# Drainage-Report\_v8.pdf Markup Summary

**Subject:** Polygon  
**Page Index:** 212  
**Date:** 8/22/2022 9:41:24 AM  
**Author:** dsdrice  
**Color:** ■  
**Layer:**  
**Space:**  
**Page Label:** [1] Layout1

RETREAT AT TIMBERRIDGE FILING NO. 2
 CONSTRUCTION PLANS
 CHECK STRUCTURES AND
 WETLAND MITIGATION AREA
 DESIGNED BY MAW SCALE DATE 4-15-21
 DRAWN BY MAW (H) 1" = 30' SHEET 20 OF 24
 CHECKED BY (V) 1" = N/A JOB NO. 1185.20

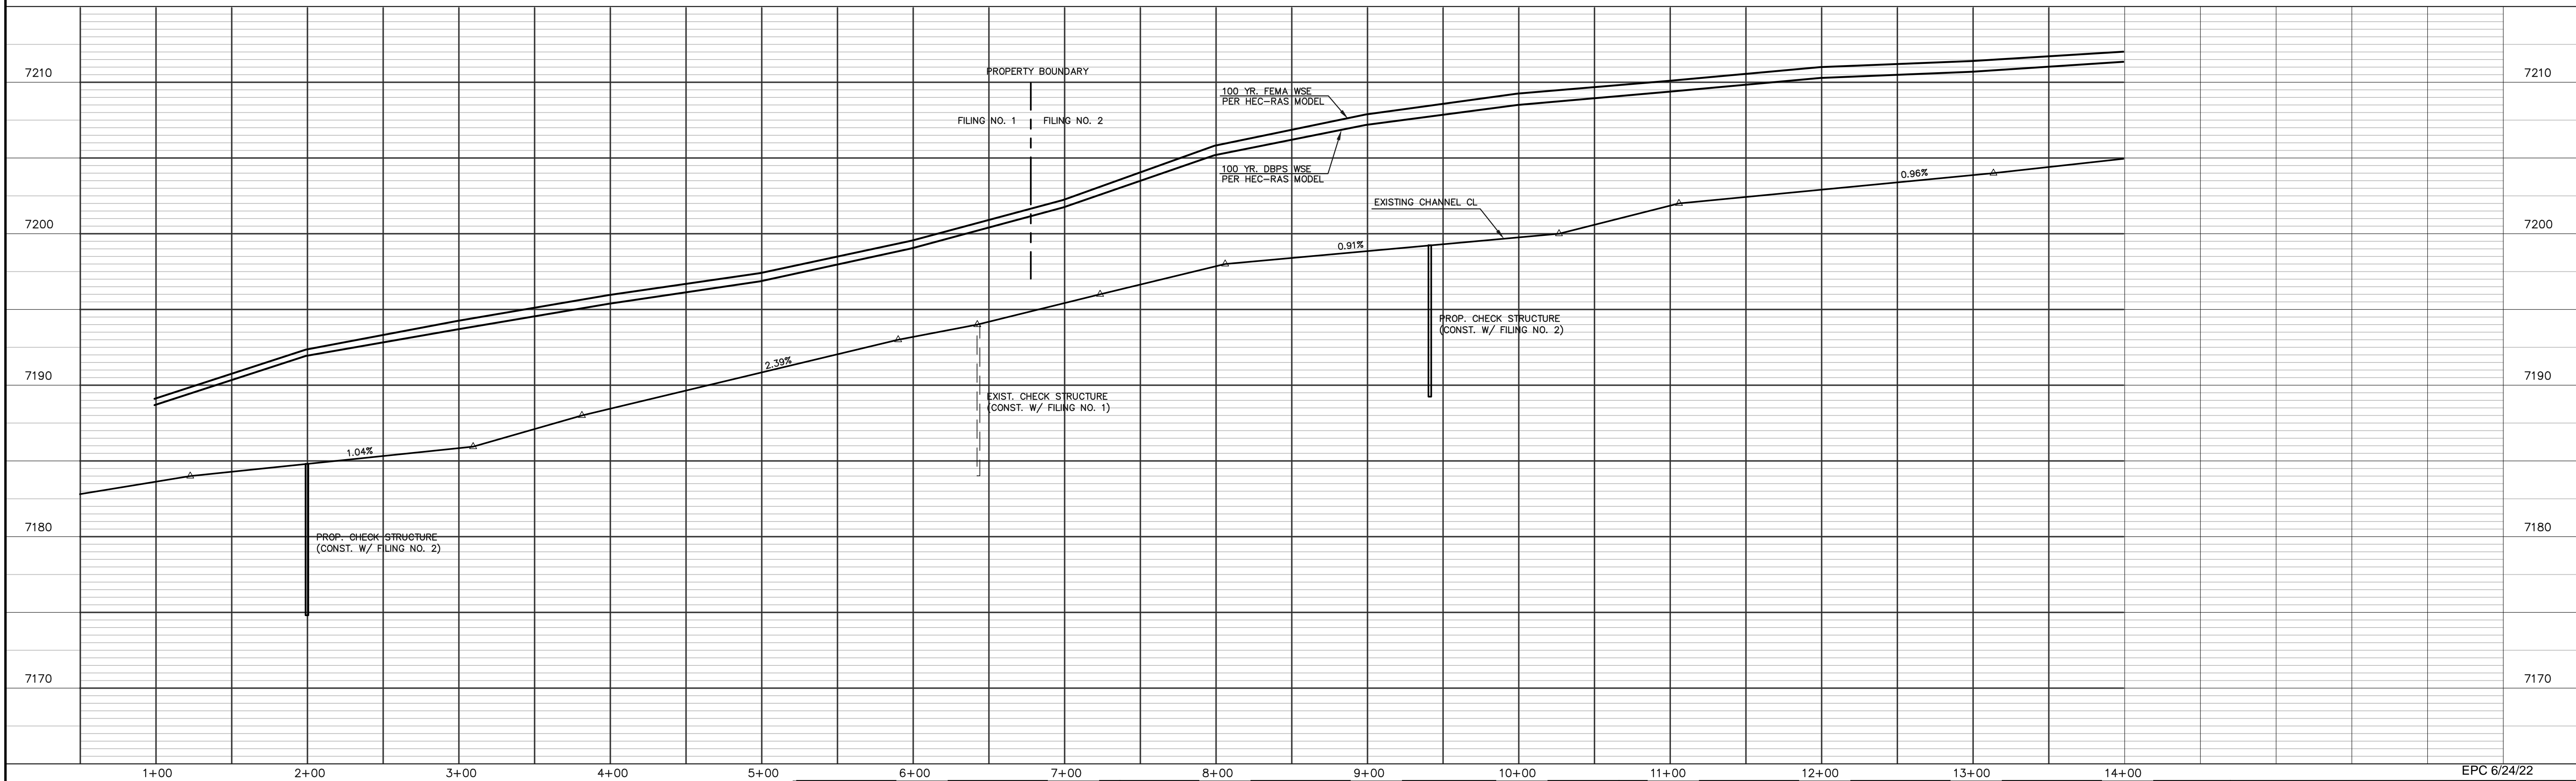
Show the wetland mitigation areas

Access ramp needs to be adjusted or another location used
